**ABP. Ref. 313361**

**Observation to Proposed SHD on Lands at Back Road & Kinsealy Lane, Kinsaley, Broomfield, Malahide, Co. Dublin**

**Submitted by: Miriam Jackson, 18 Hazelbrook, Kinsealy Lane, Malahide, Co. Dublin. K36 TC91**

**23 May 2022**

PERMITTED LAYOUT AS PER PLANNING REG. REF. NO. F13A/0459

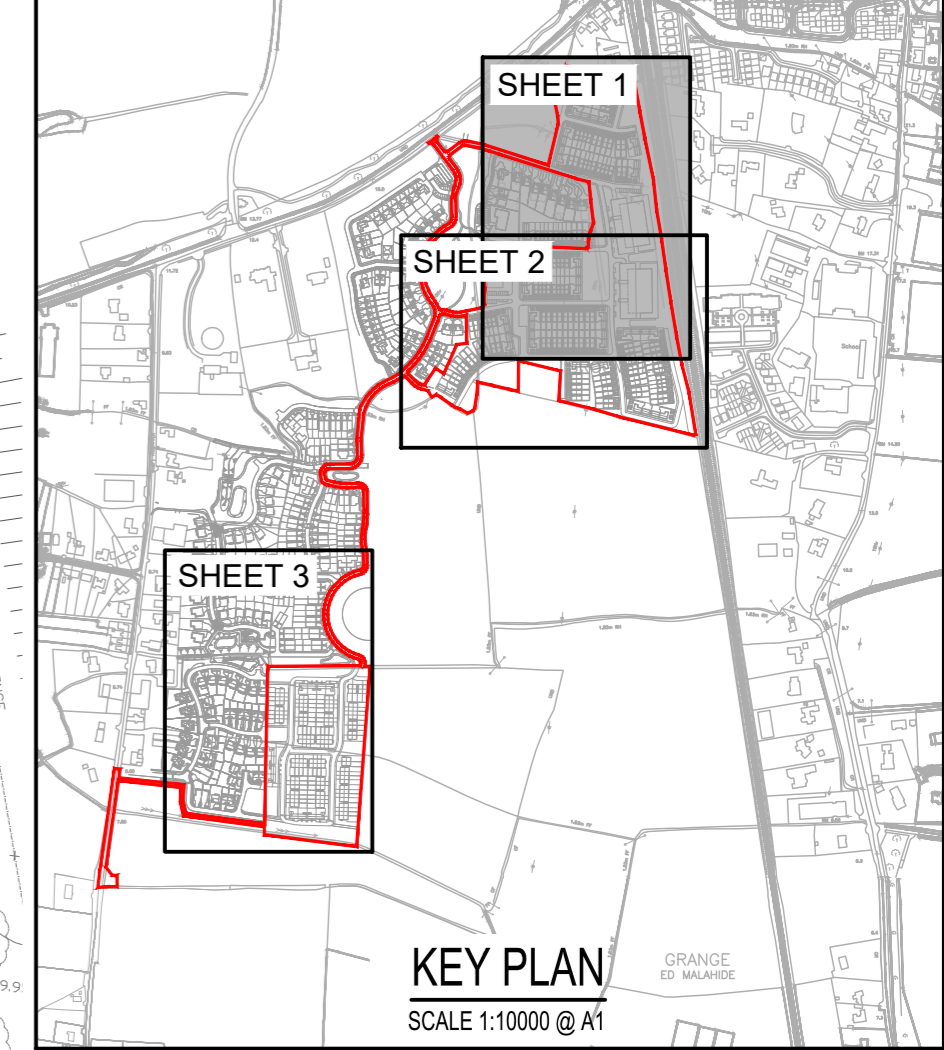
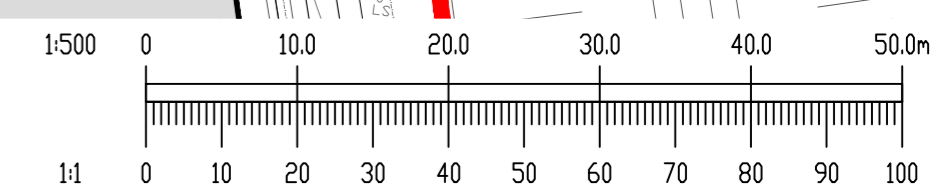
1. Hazelbrook entrance/egress and the road from the farmer's entrance directly passing Nos.25-30 was never originally designed to cater for the volume of traffic proposed from the new development and all the houses at Brookfield (and Ashwood).

2. This is evidenced by the layout, width and turn of the road, passing adjacent to an amenity green and the proximity of these houses to the road. It is clearly a secondary feeder road to serve the needs of the houses abutting.

7. Without adequate protection/screening of the proposed link road through Hazelbrook the green amenity is at risk of being lost to the residents as a result of safety fears for children

and adult users alike. This is contrary to Fingal CC objectives and unfair to Hazelbrook residents who were not consulted in this process. The proposed traffic calming measures do not mitigate future traffic volumes.
